# CITY OF ALBUQUERQUE

August 22, 2022

**Re: Kairos Power Expansion**  
**5201 Hawking Dr. SE**  
**Traffic Circulation Layout**  
Architect's Stamp XX-XX-XX (Q16-DA5000A)

Based upon the information provided in your submittal received 07-26-22, the above referenced plan cannot be approved for Building Permit until the following comments are addressed:

ENLARGED TRAFFIC
CIRCULATION LAYOUT

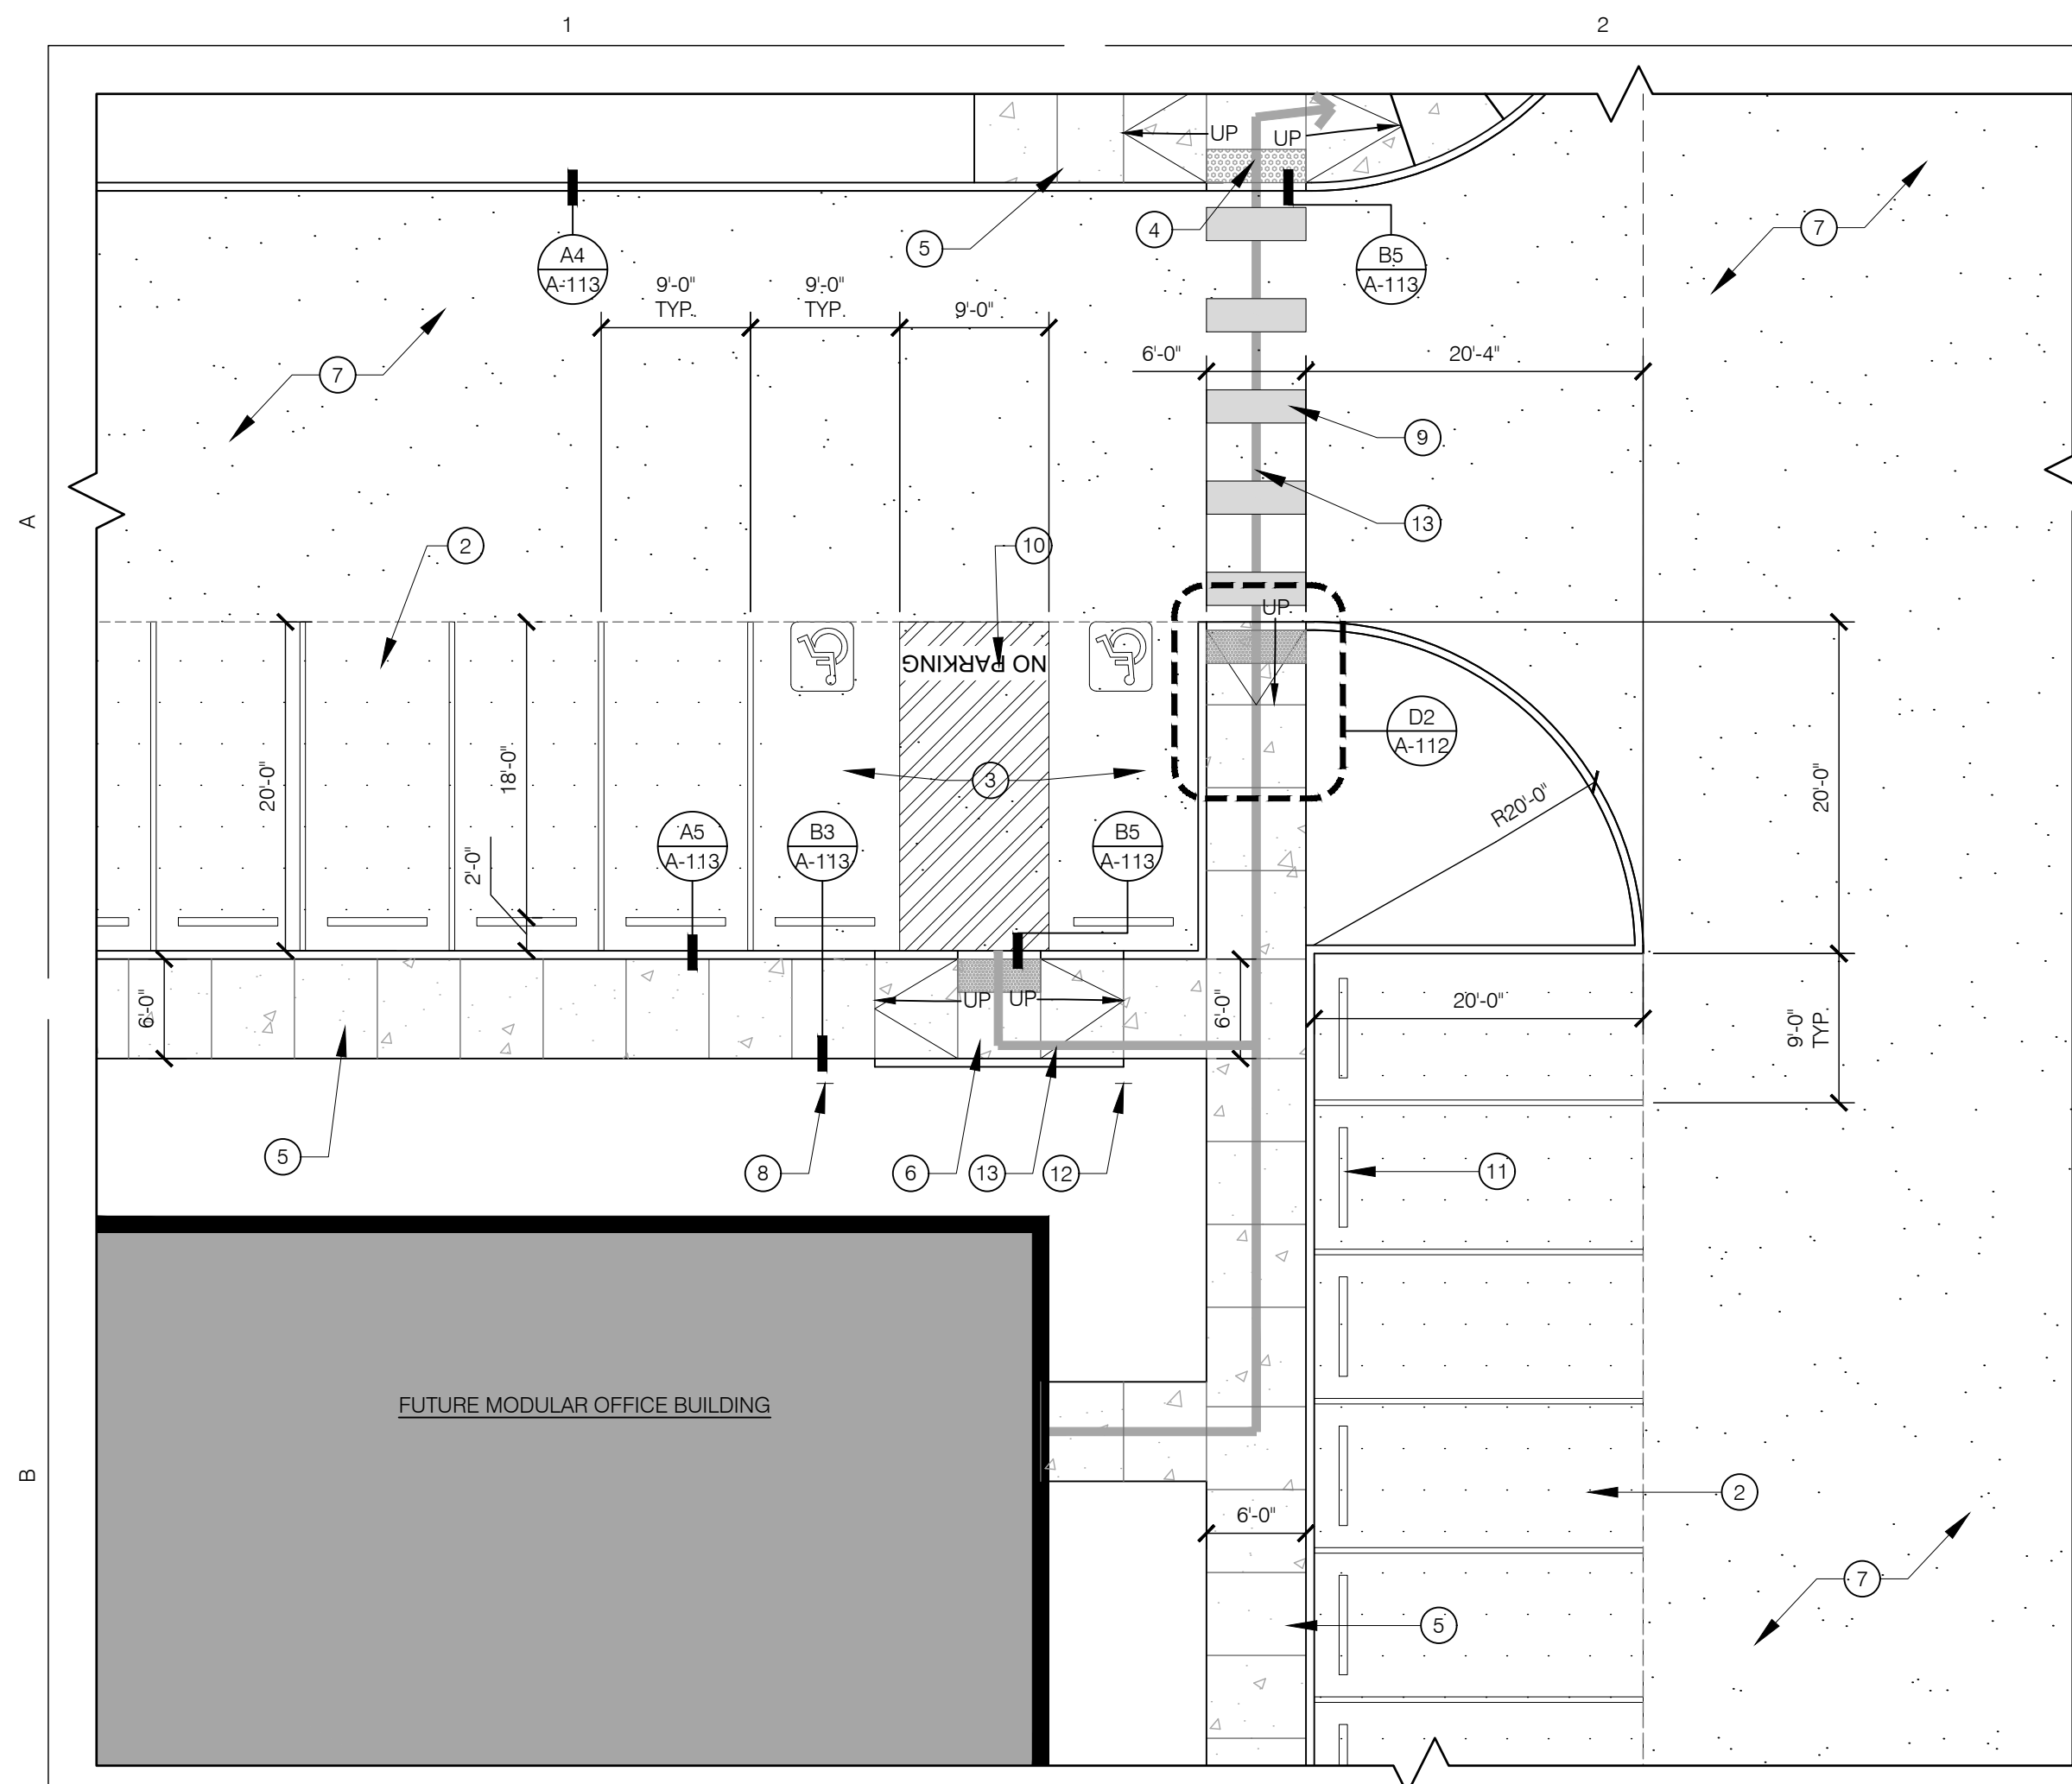
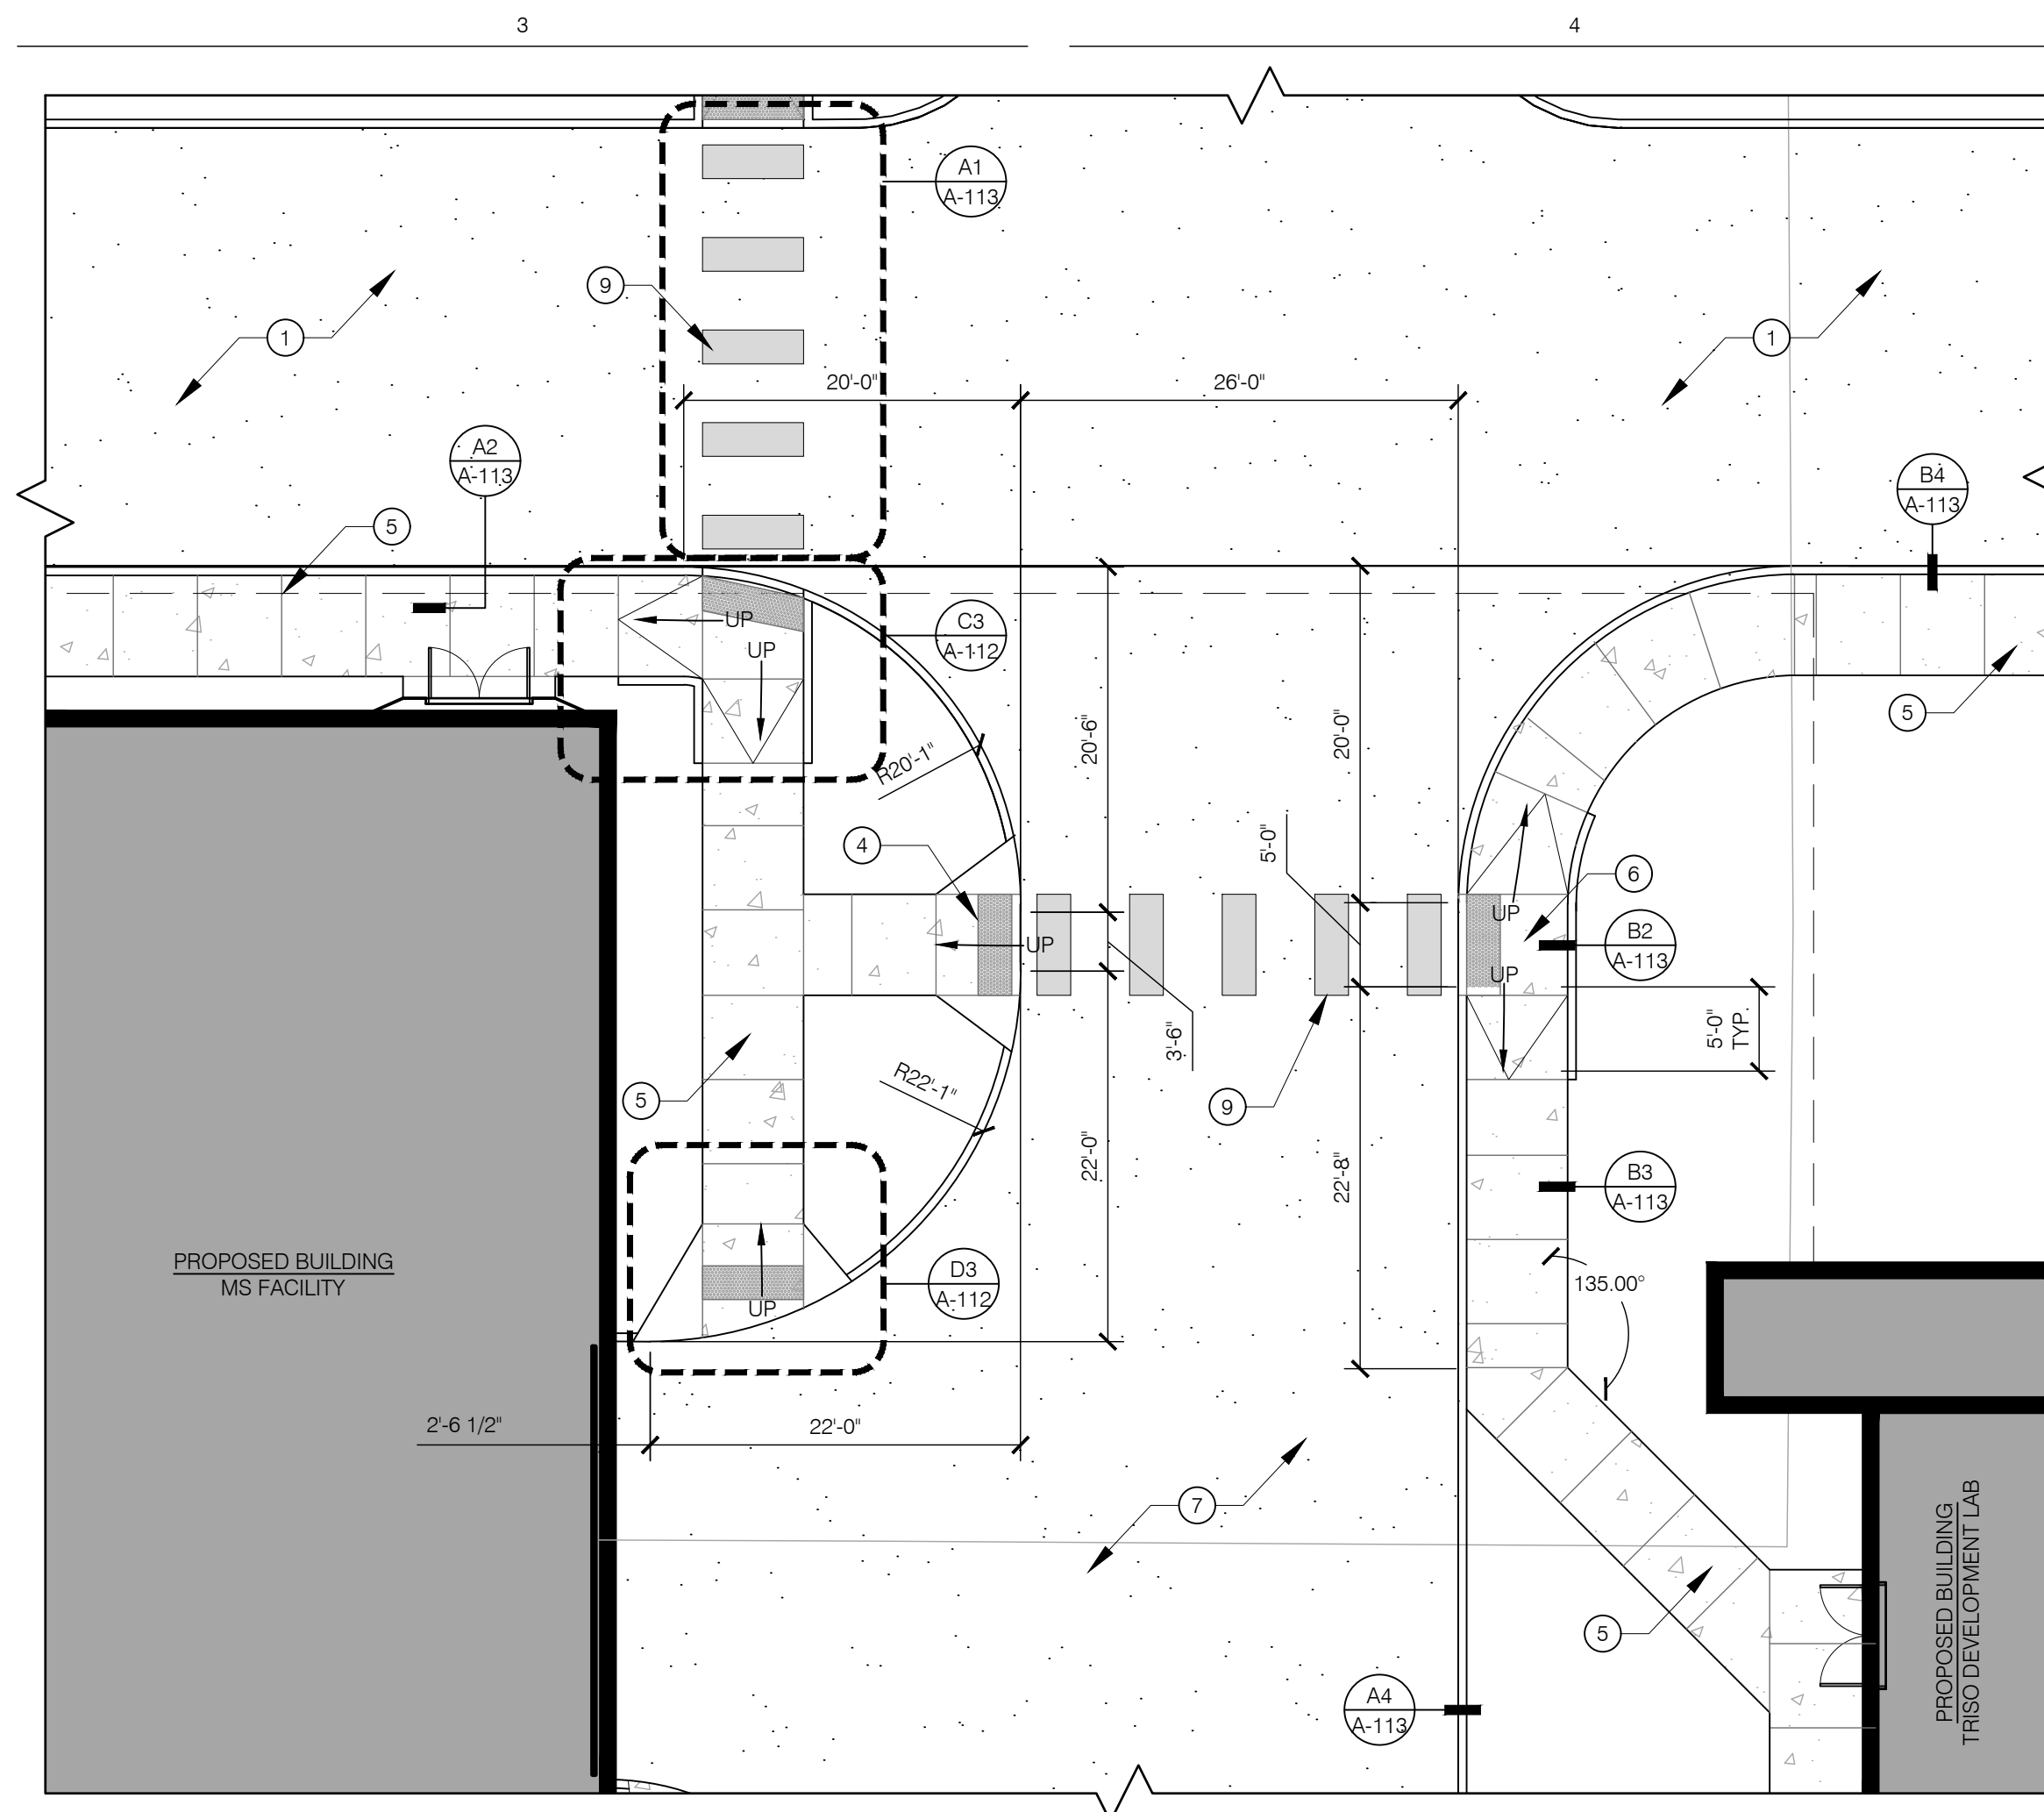
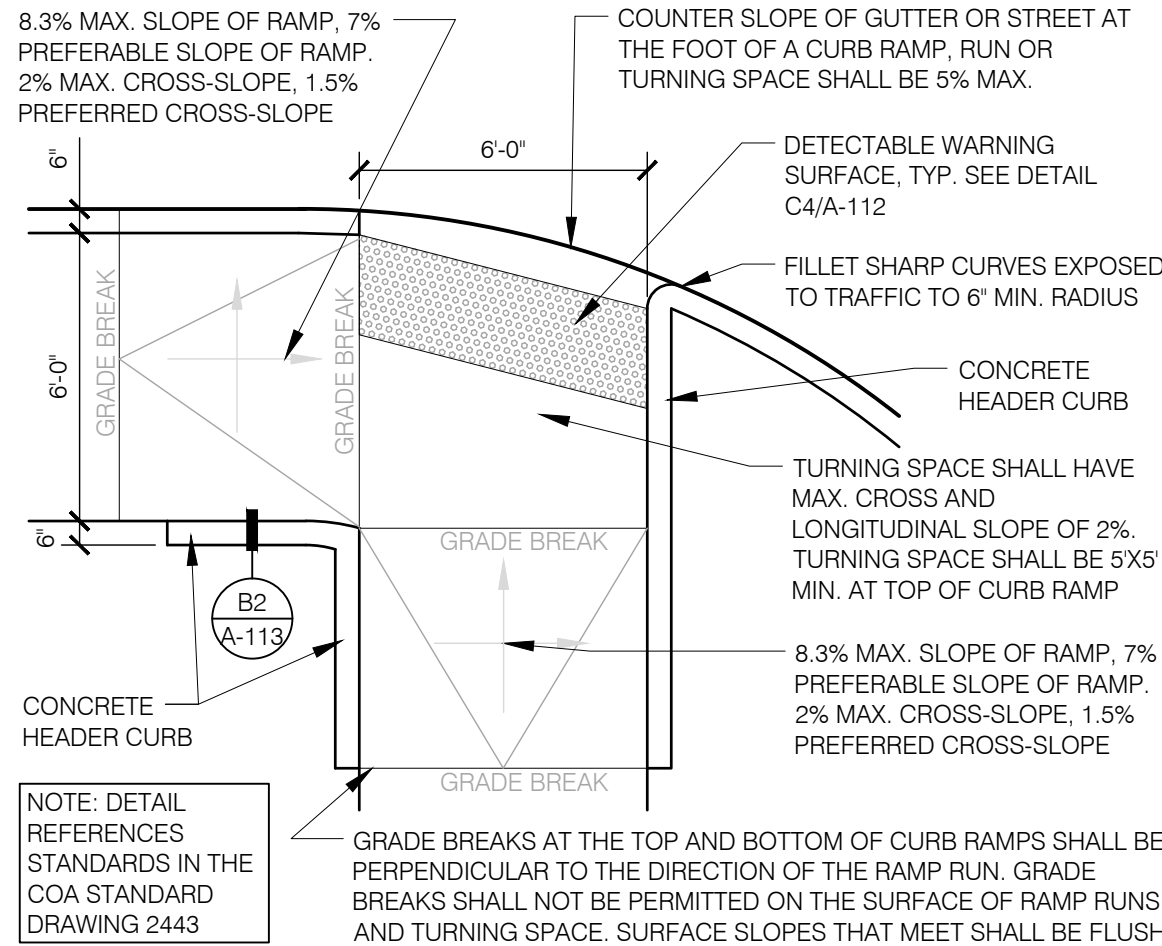
7. ADA curb ramps must be updated to current standards and have truncated domes installed.
8. Keynote 18: provide all proposed ramps details and reference COA std dwg.
